Re: Planning Application R/175/12

WEST 1/100

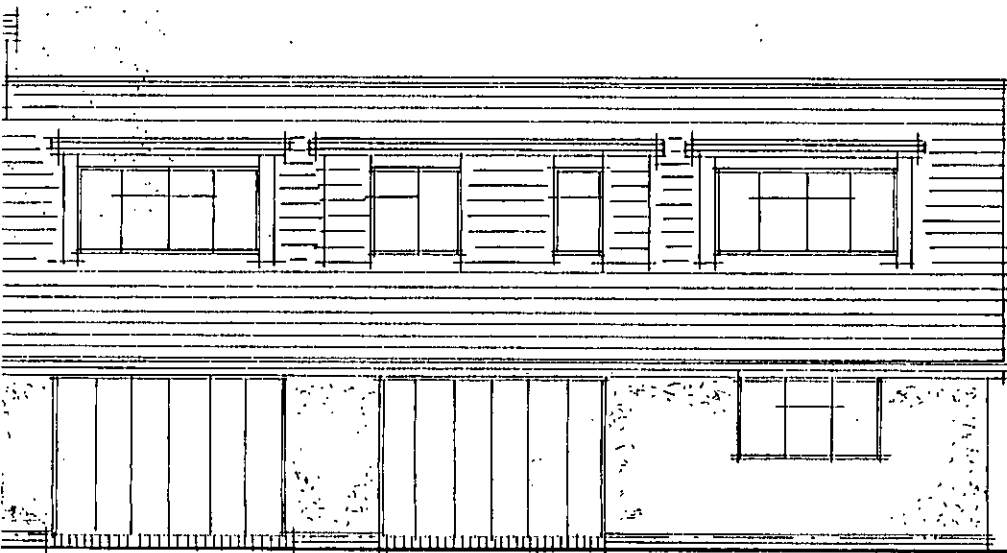
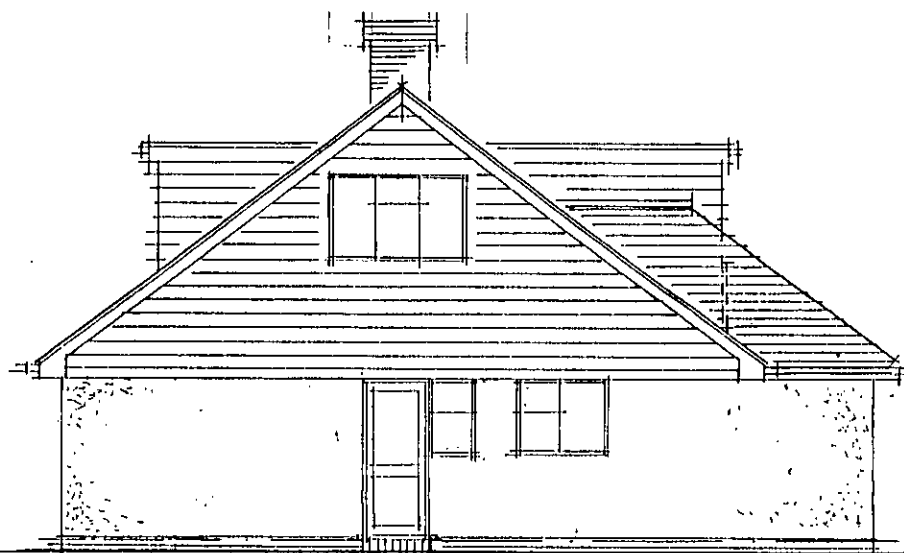
The position of this two story building will be 8 metres nearer the northern boundary; approx 6 metres from fence line as opposed to 14 metres for existing bungalow.

The proposed development to be considerably larger, higher, and very much closer to the northern boundary, with north facing dormer windows overlooking our garden and bungalow bedrooms and living area.

BLOCK PLAN 1/500

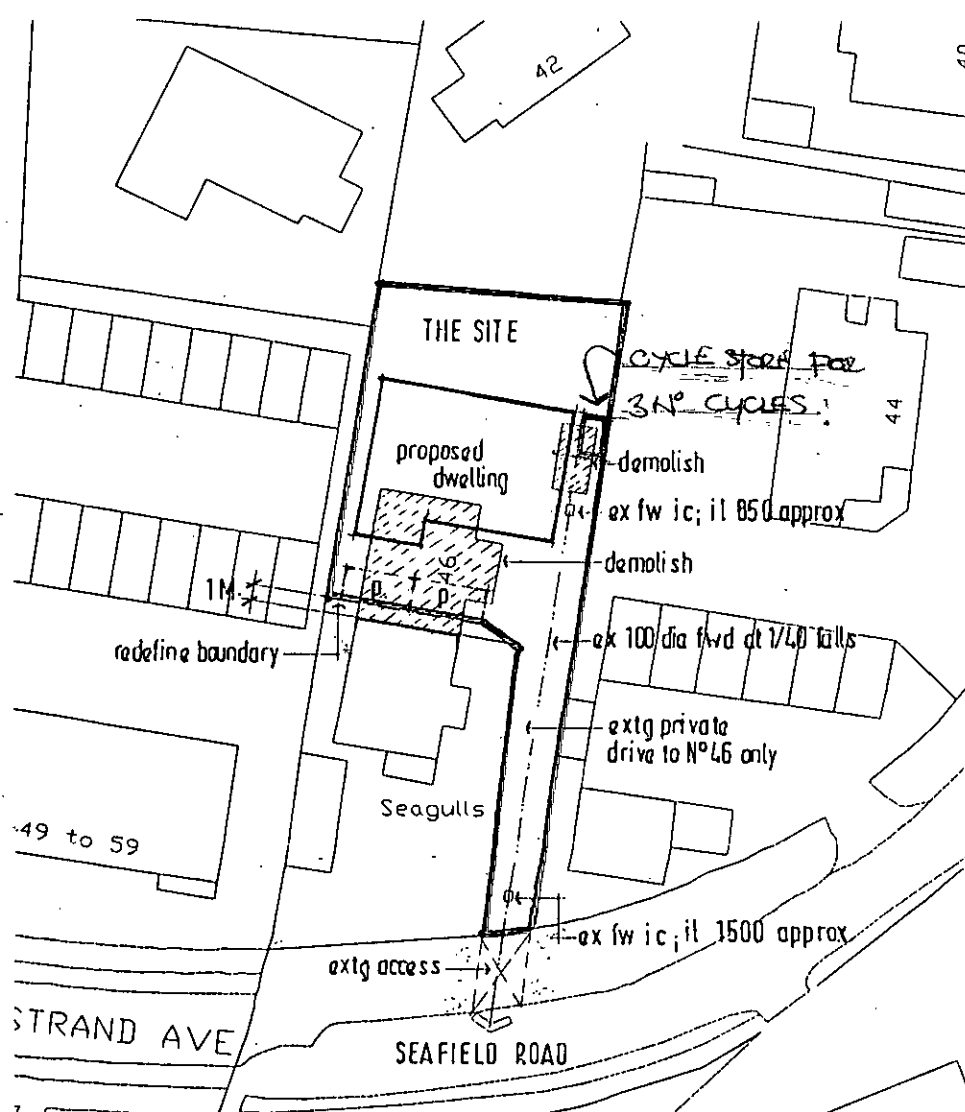
The site plan provided by the applicant shows mixed hedging and small rowan trees on the northern boundary of the site. There is in fact a mature Holm Oak centrally situated on this boundary, not shown on the location plan 12/3907/1 (see photographic image supplied). As it is an evergreen it provides some year round privacy. If this proposal is allowed to proceed as submitted, we would ask that some protection is afforded this tree to maintain a degree of privacy and reduce the visual impact of the proposed building.
